CITY OF ALBUQUERQUE

RE: 2414 Manuel Torres
Grading and Drainage Plan
Engineer's Stamp Date: 7/1/24
Hydrology File: F13D027

Based upon the information provided in your submittal received 06/14/24, the Grading and Drainage Plan is **not** approved for Building Permit. The following comments need to be addressed for approval of the above referenced project:

<div>ENGINEER'S SEAL</div> <div></div> <div>DAVID SOULE P.E. #14522</div>	TRACT 3 LANDS OF TORRES 2414 MANUEL TORRES LANE	DRAWN BY DEM
	GRADING AND DRAINAGE PLAN	DATE 5-3-24
	 P.O. BOX 53924 ALBUQUERQUE, NM 87199 (505) 321-9099	SHEET # C1
		JOB #

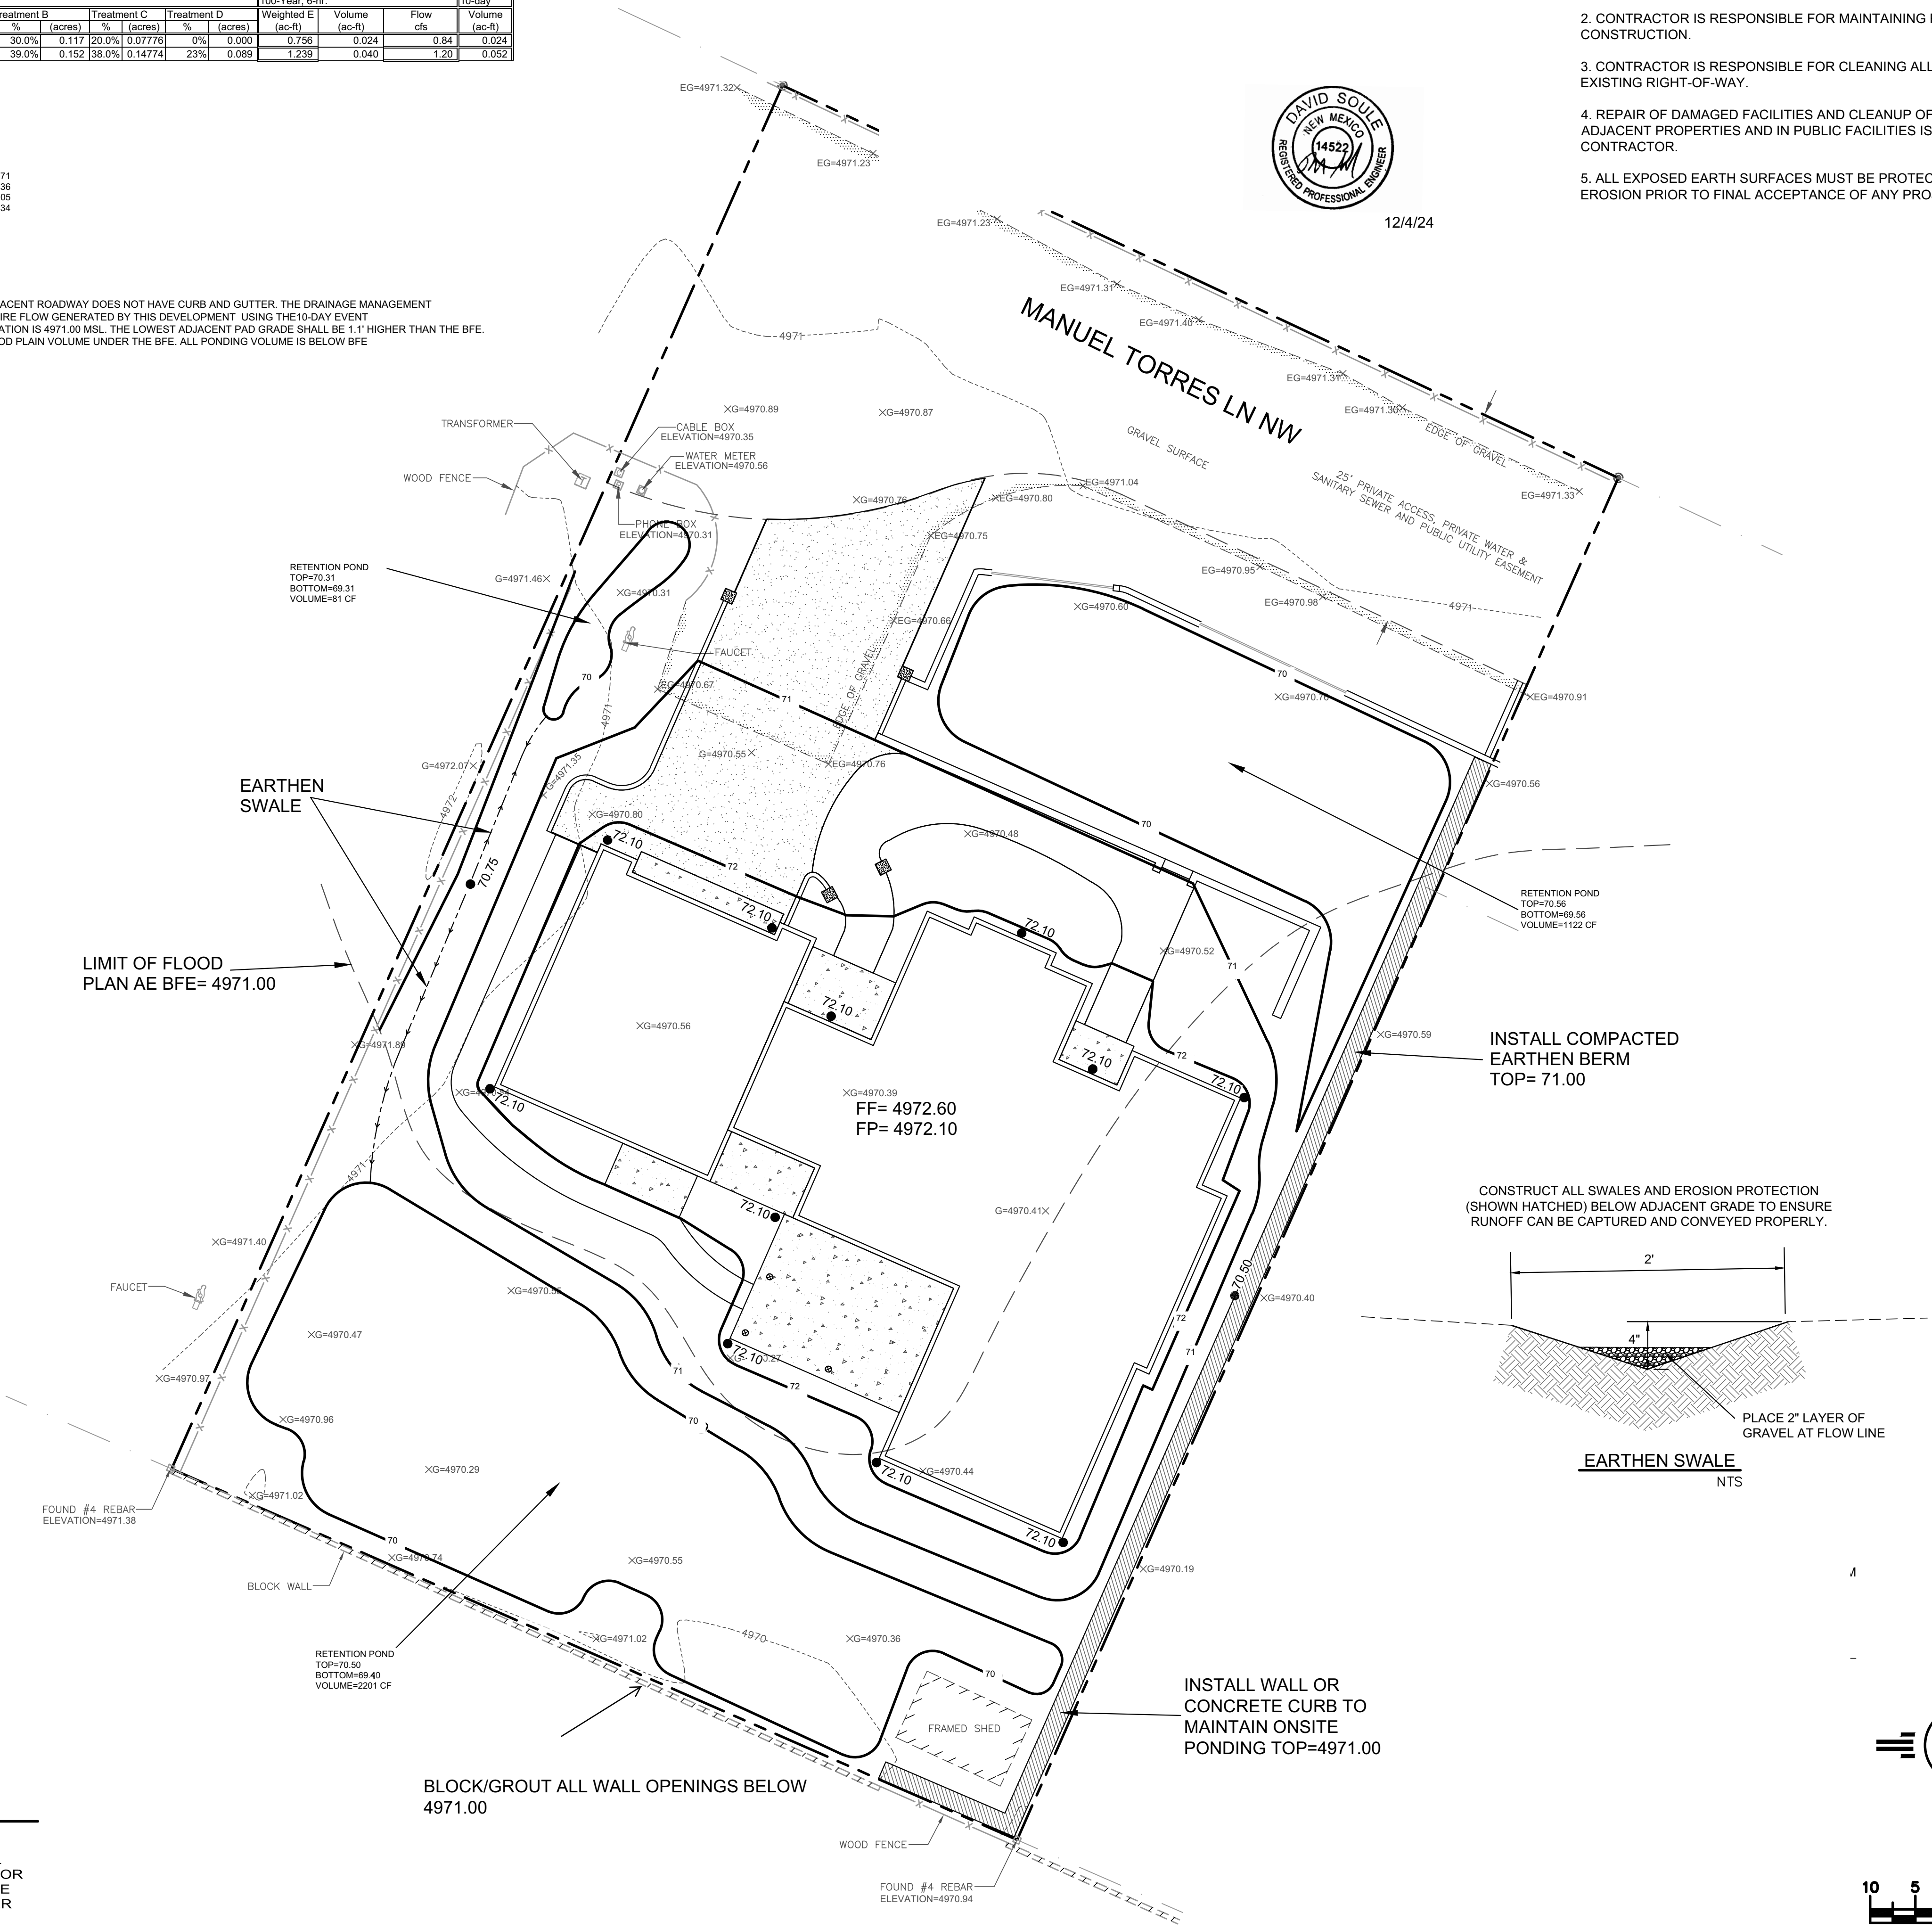
1. A portion of this project is located in a floodplain (AH-EL 4971') and a floodplain development permit must be obtained. The permit application must demonstrate zero rise to the base flood elevation, unless a Letter of Map Revision (LOMR) is being prepared. Please contact Rudy Rael, CFM for more information regarding floodplain development permits (rrael@cabq.gov or 505-924-3977).
2. Since this site is in the Valley region, please follow Article 6-5 Valley Drainage Criteria of the DPM. The following conditions must be applied to the site:
 - A permanent perimeter wall or barrier around the development is required to contain the 100 year 24 hour storm developed runoff.
